**Application by Highways England for M54 to M6 Link Road  
 Comments and Responses at Deadline 7 - 26<sup>th</sup> March 2021  
 Responses From: Allow Ltd (Allow)**

**1. Comments on 8.25 Applicant’s Response to ExA’s Further Written Questions:**

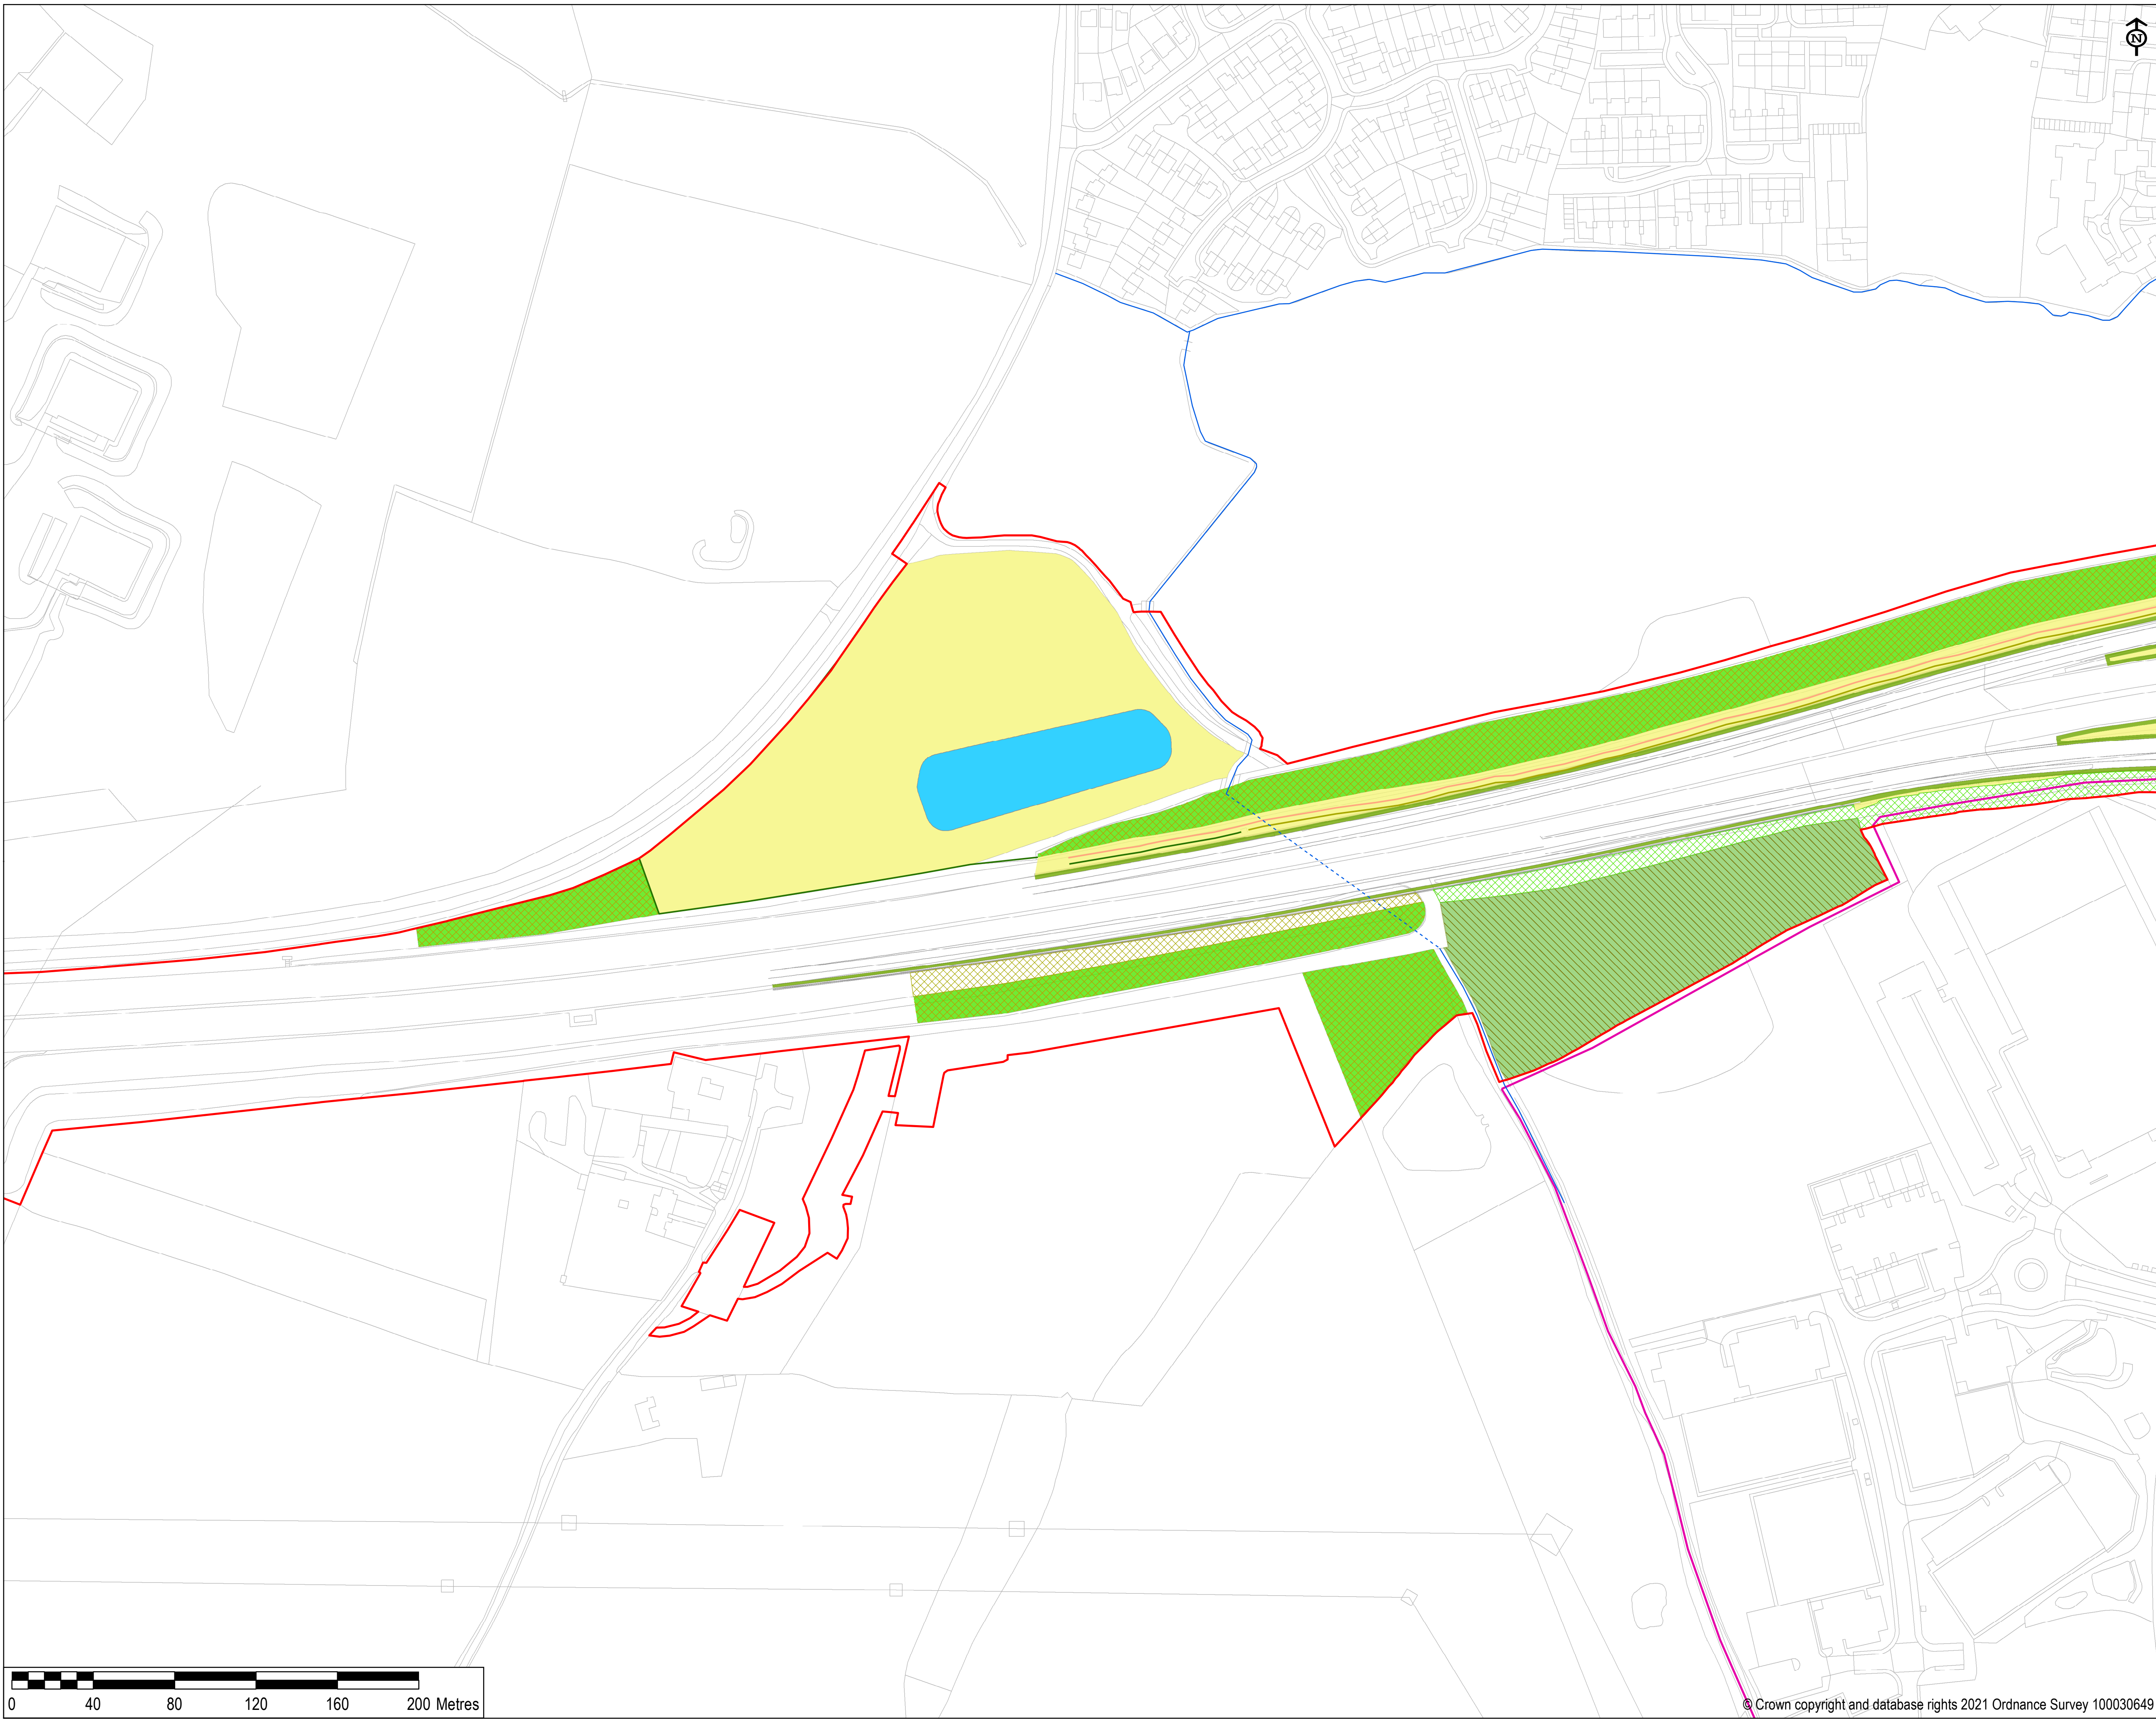
- 1.5 It is assumed that the “grassland” area is comprised of grass embankments alongside the Shrubbery and a small area around the proposed pools in 5/2. The area of the proposed mitigation pools and grassed banks surrounding them shown on the revised environmental masterplan is approximately 0.57 ha.

- 1.6 The area shown on the revised environmental masterplan shows the area of 5/2 as approximately 6.1 ha which is well in excess of the 5.41 ha or thereabouts, (4.84 + 0.57), that would be anticipated from the Applicants calculations. Please can the applicant clarify the areas shown on their masterplan?
